# Rezoning Transportation Analysis

Petition Number: 2024-003

## Revision Log:

Date	Description
02-21-24	First Review (IW)
03-20-24	Second Review (IW)
04-24-24	Third Review (DR)

SHEET NUMBER  
**RZ-2**

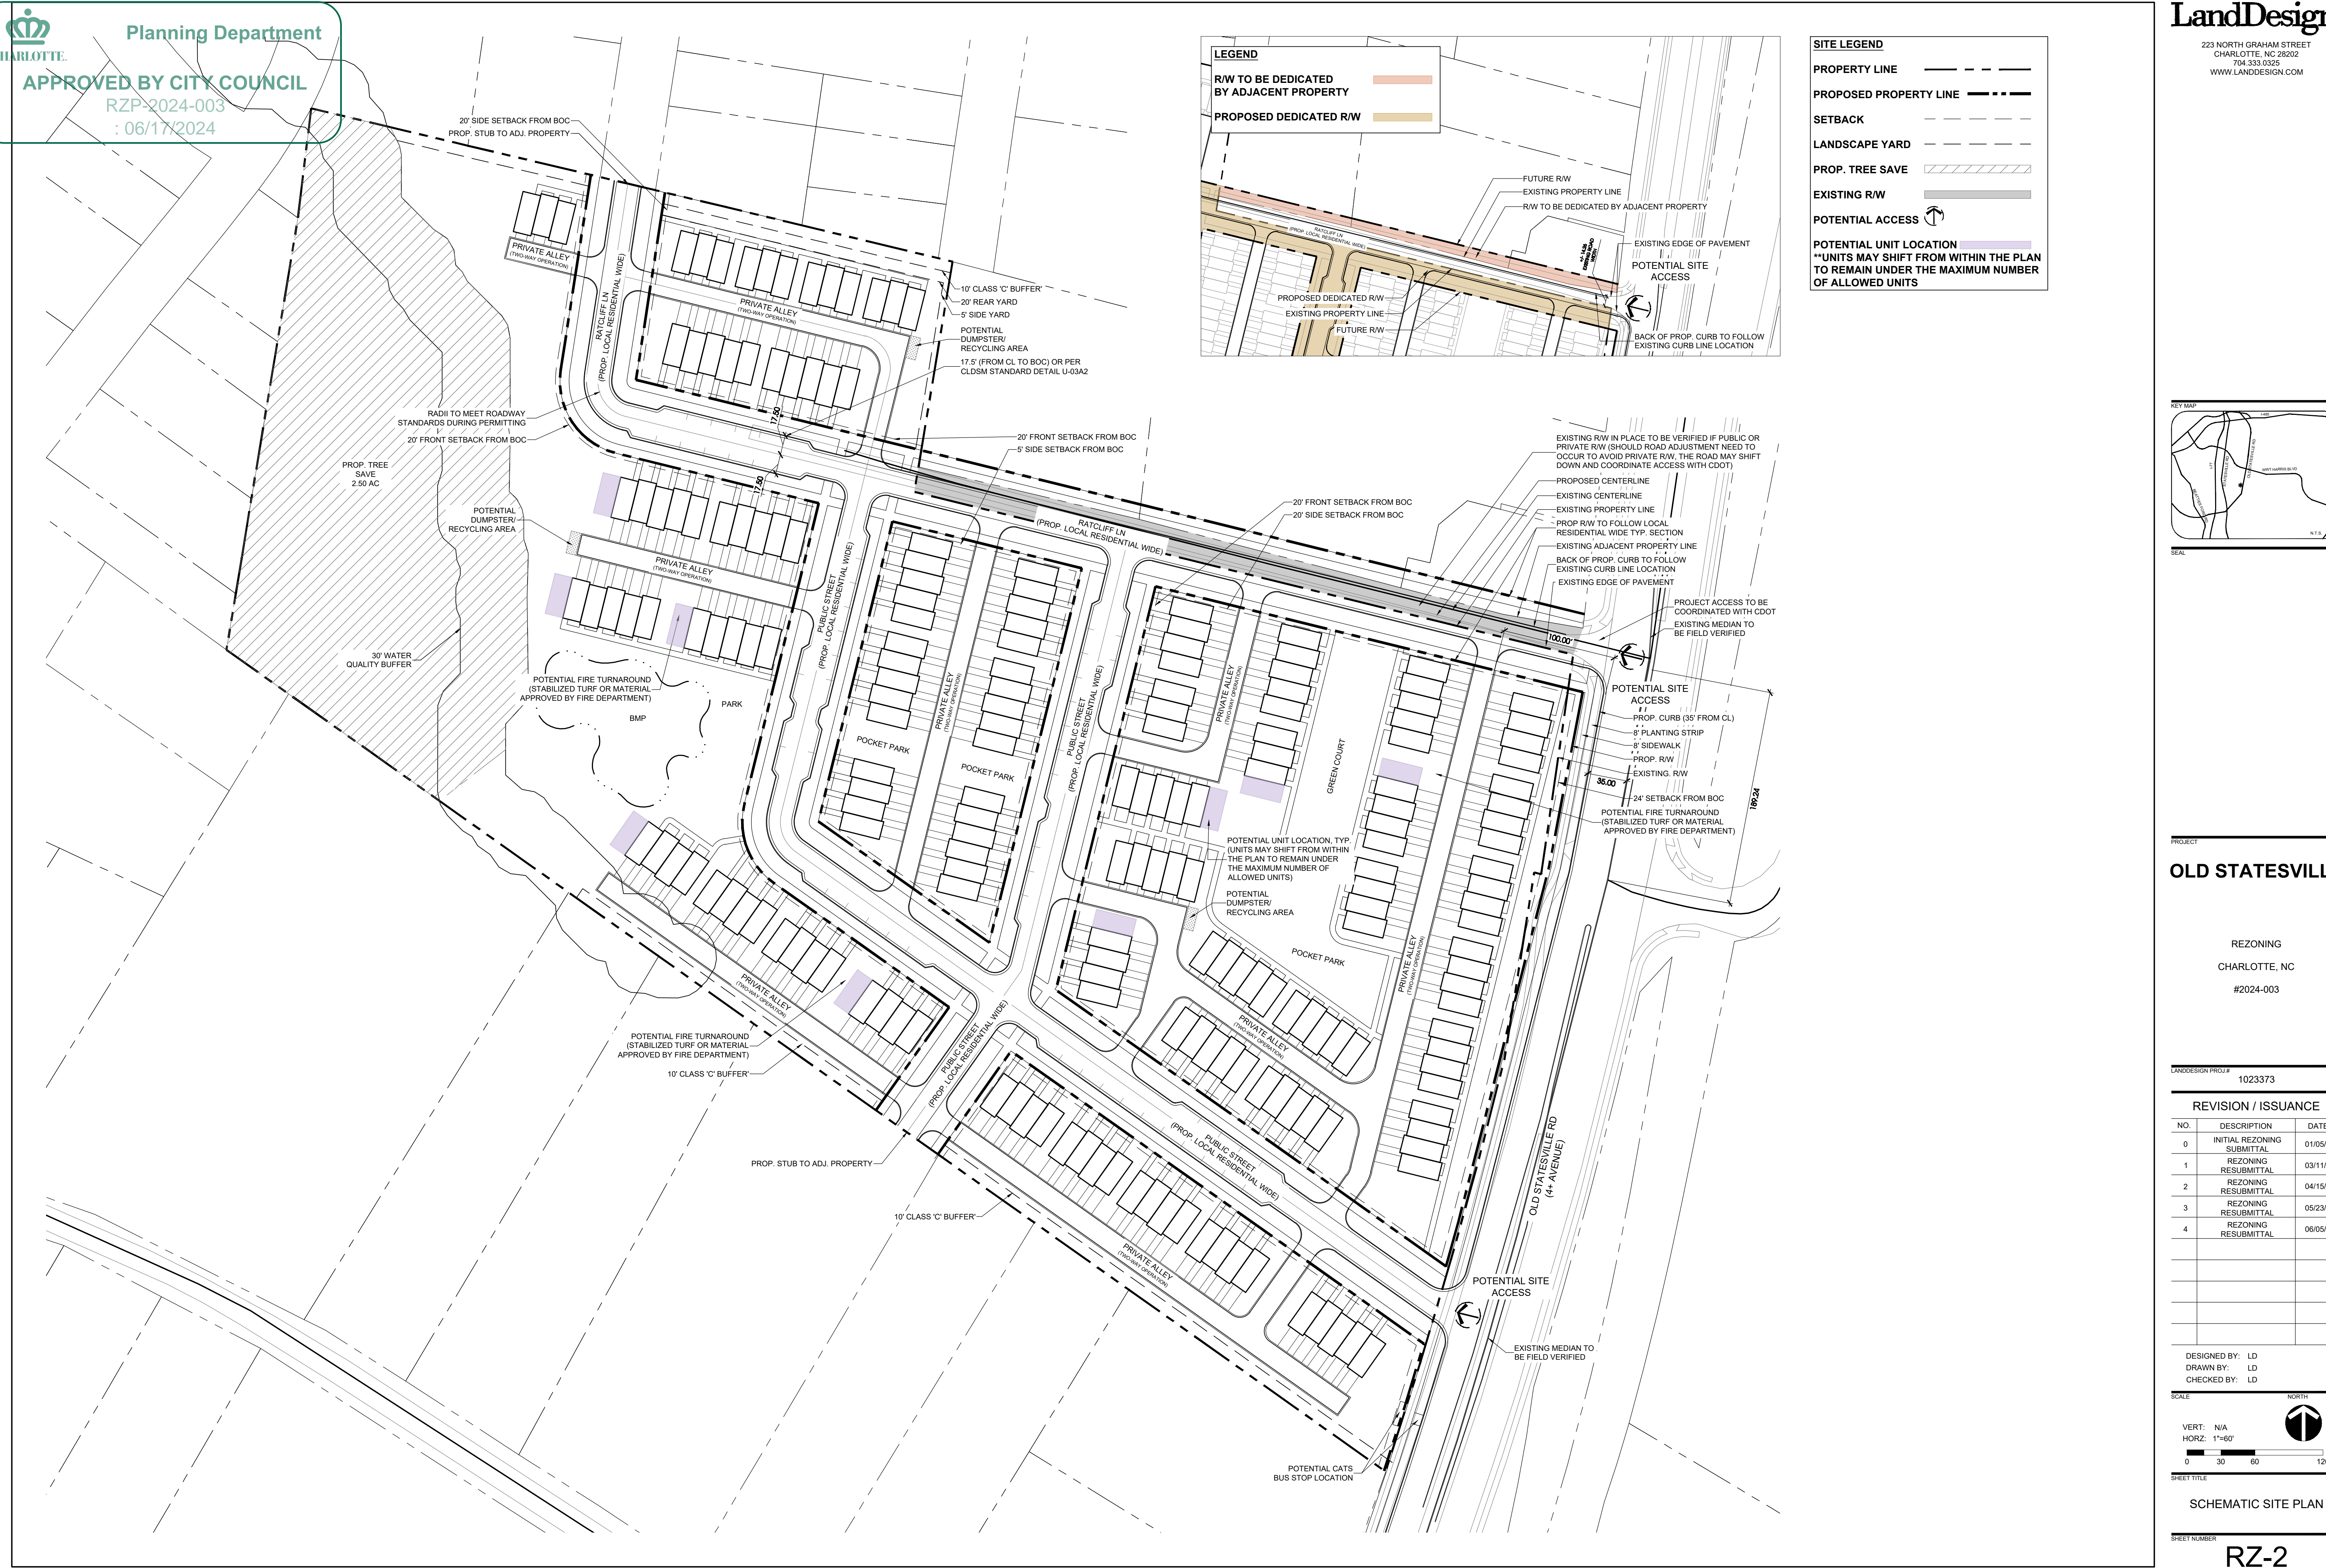
14. **Outstanding Comment from 02-21-23:** Add a conditional note specifying "All transportation improvements will be approved and constructed before the site's first building certificate of occupancy is issued."

**Clarifying Comment 03-20-24:** Conditional note 3.C states "Required roadway improvements" this needs to read "All transportation improvements" as this includes sidewalks, etc.

15. **Clarifying Comment 04-24-24:** To ensure that the information is being understood and captured as intended by CDOT change note to match what was stated in the original issue "All transportation improvements will be approved and constructed before the site's first building certificate of occupancy is issued."

SCHEMATIC SITE PLAN

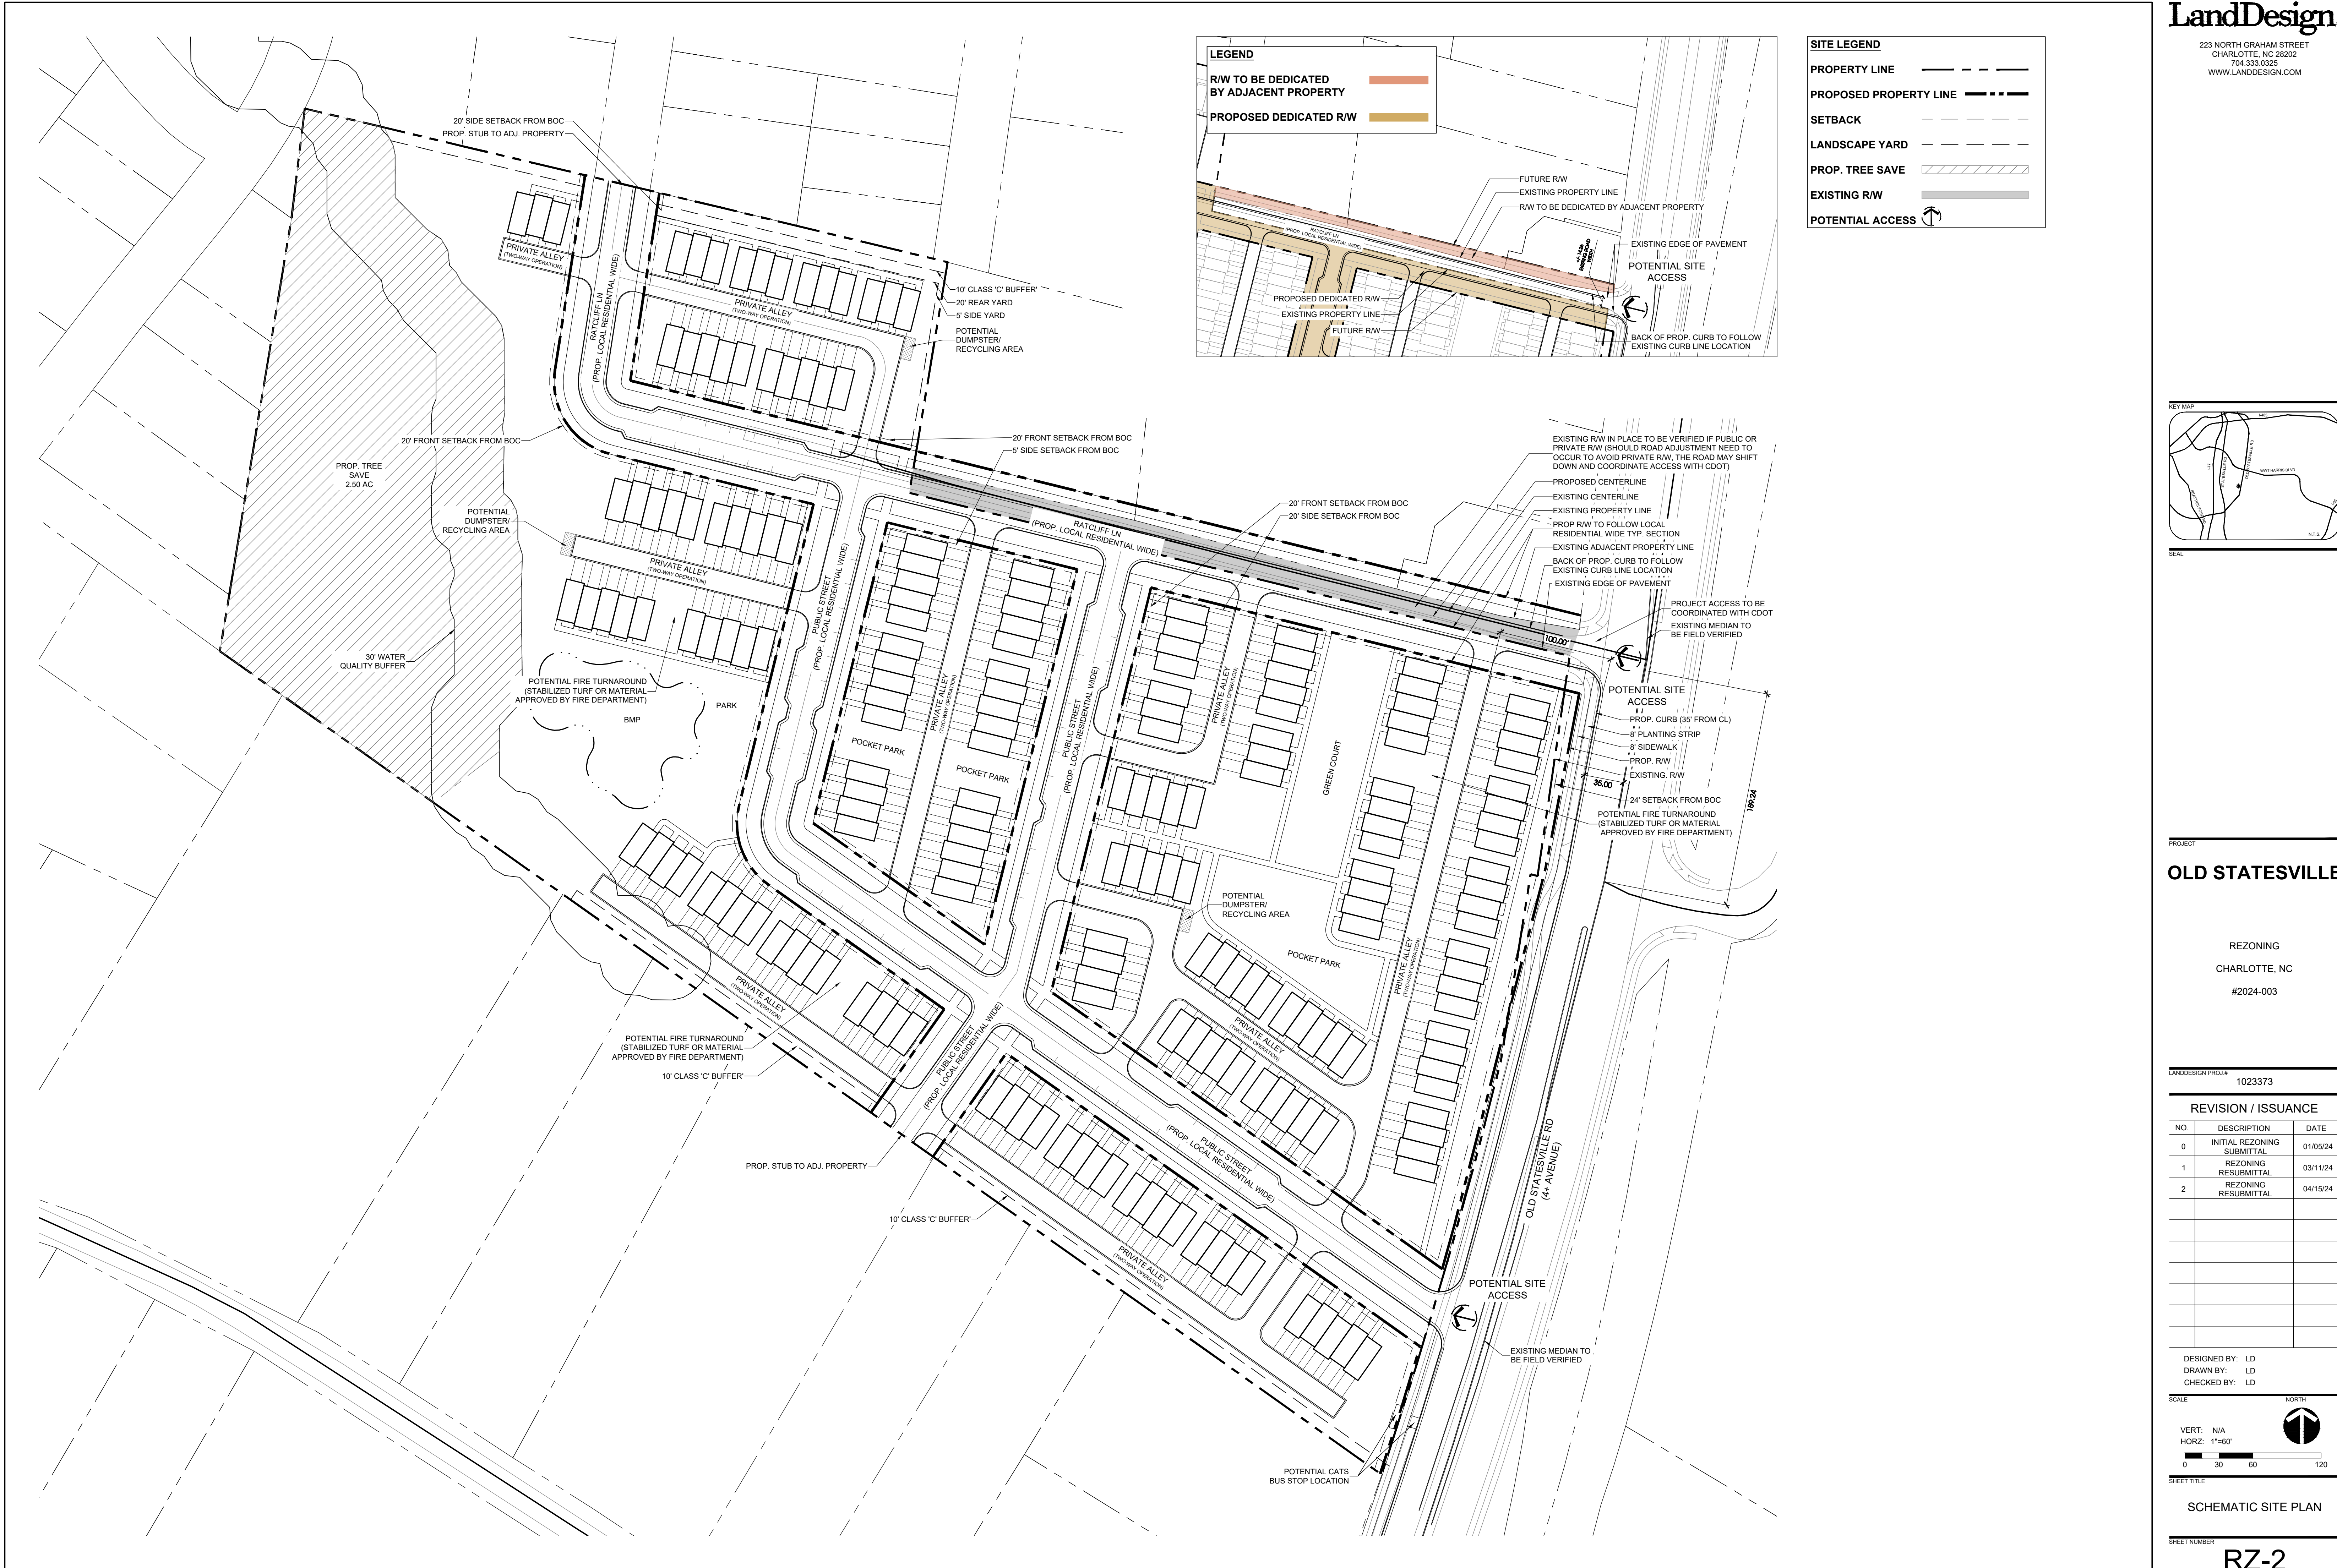
b. **Ratcliff Lane:** Location of future back of curb and gutter needs to be moved to 17.5 feet from the road centerline per Article 33 in the UDO.

CLDSM standard U-03A2 Local Residential Wide Street

Label and dimension the curb and gutter from the centerline for each road on the site plan.

**Clarifying Comment 03-20-24:** The site plan calls out curb line to match existing but does not state what that existing dimension is. Conditional note 3.g. states that future boc is 17.5'. Add additional information to call out on site plan to show that both of these items are stating 17.5' from centerline.
